Ref: - S6/2013/2202/FP - Erection of side, rear single storey, and side and rear first floor extensions at 17 Kingsmead Cuffley Potters Bar

We write to comment on and object to the proposed plans for the above mentioned extensions as follows:-

SOUTH ELEVATION 1:50

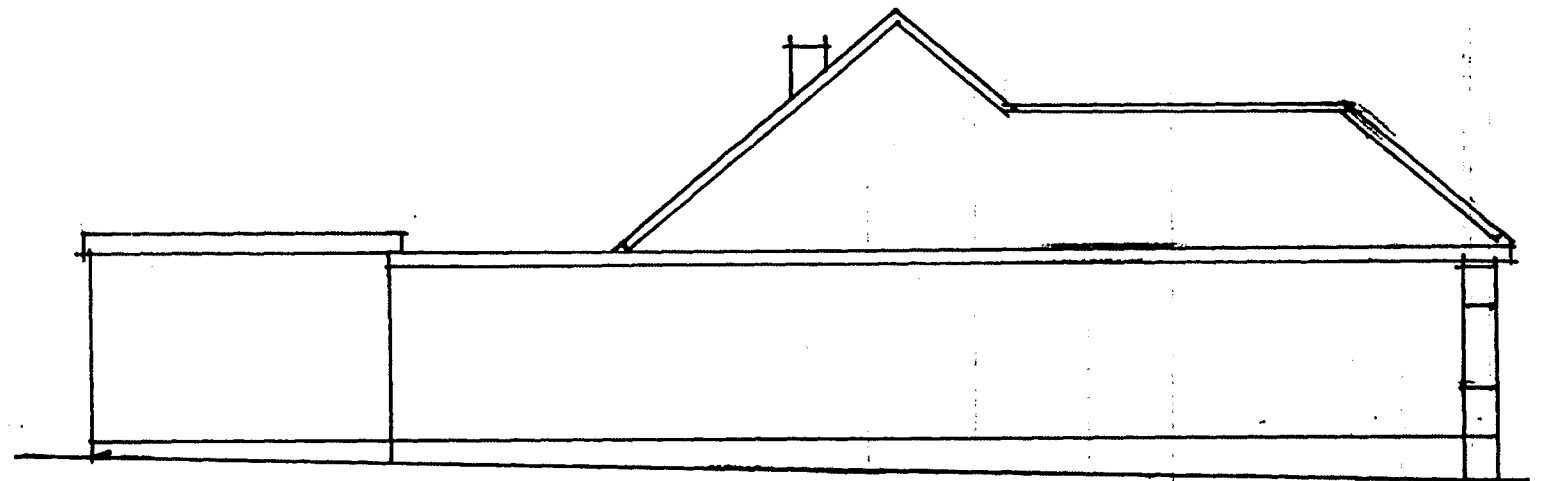
4. The windows proposed would completely overlook our garden and living areas taking away the privacy we currently enjoy. Another error in the drawings is that the existing windows in the existing south elevation are not shown.
